Preliminary Drainage Report
Final Drainage Report
for
Estates at Rolling Hills Ranch Filing 1
at
Meridian Ranch

EL PASO COUNTY, COLORADO

**PUDSP-19-007 &
SF-19-019**

Figure 2: FEMA Floodplain Map

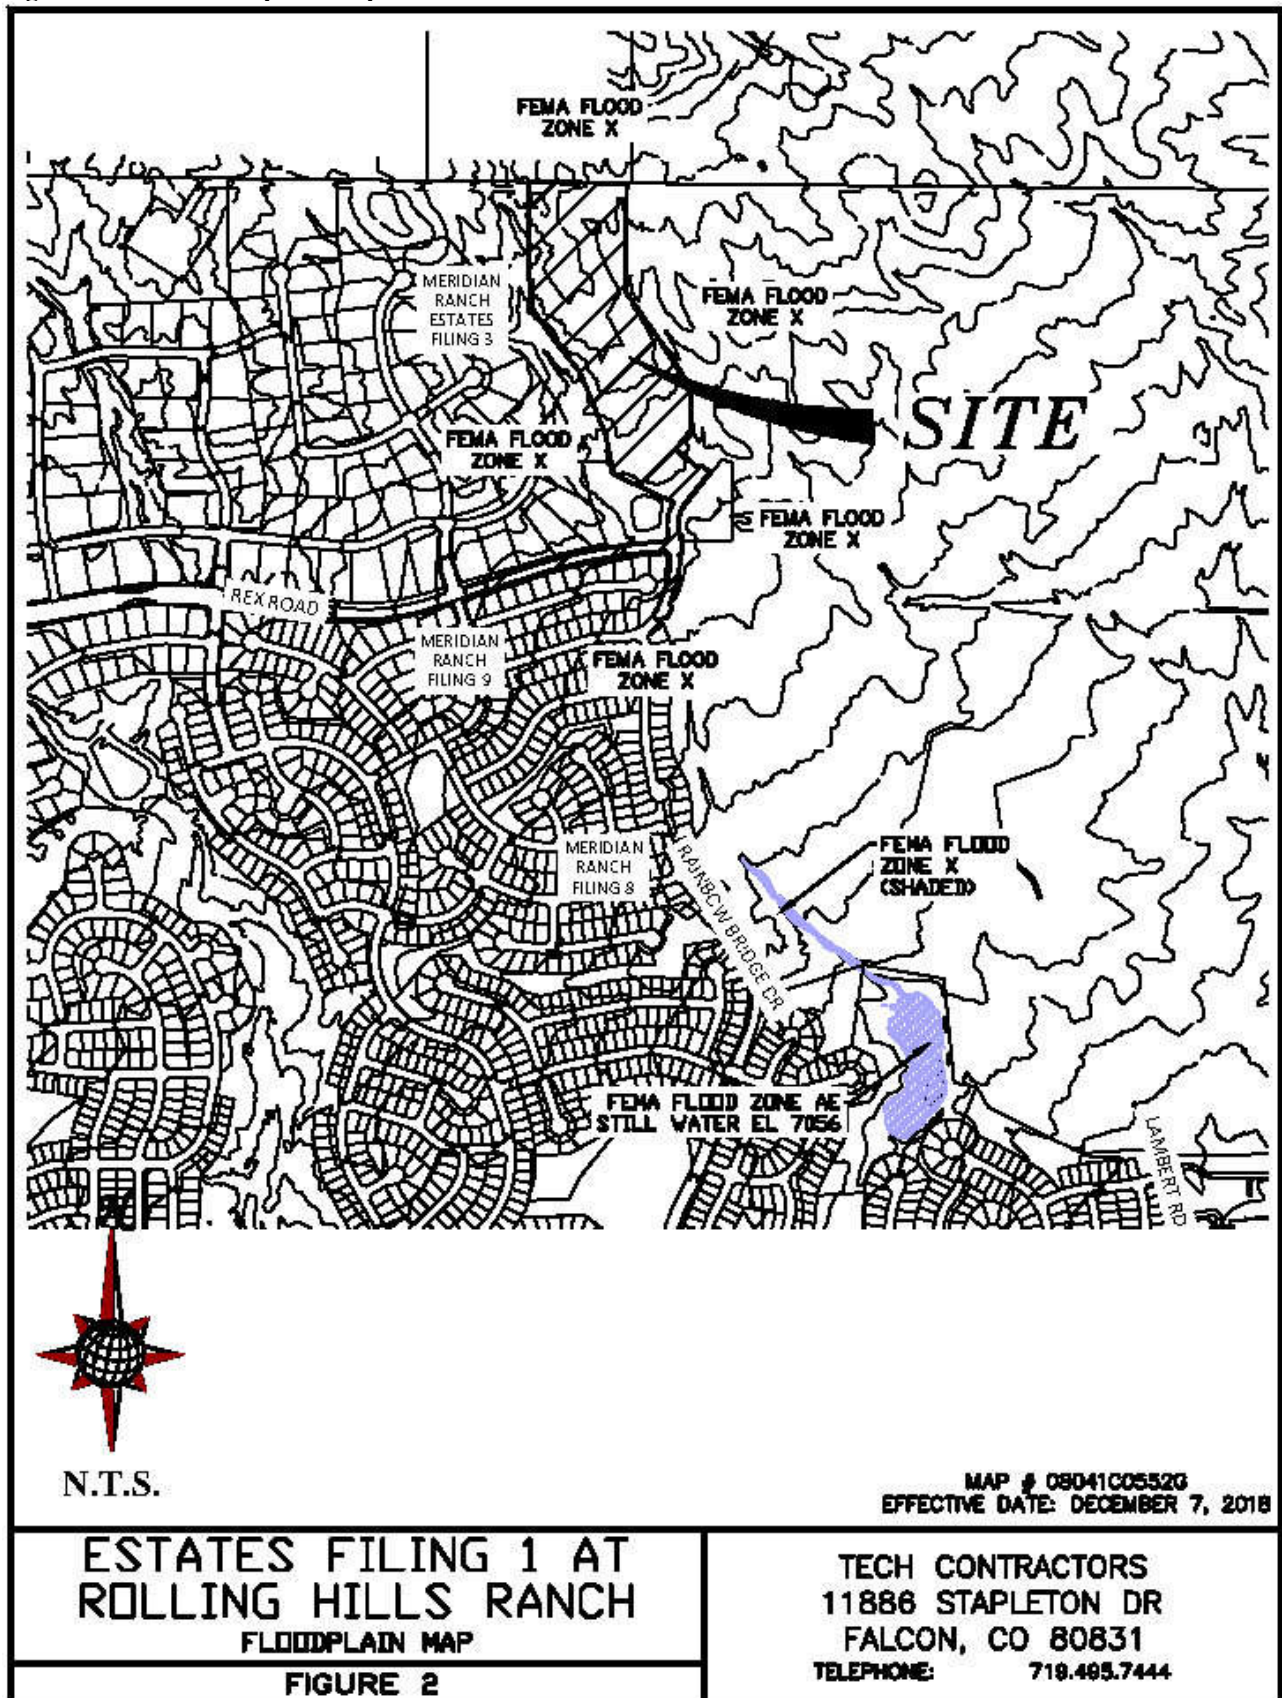
Update reference to the current FIRM
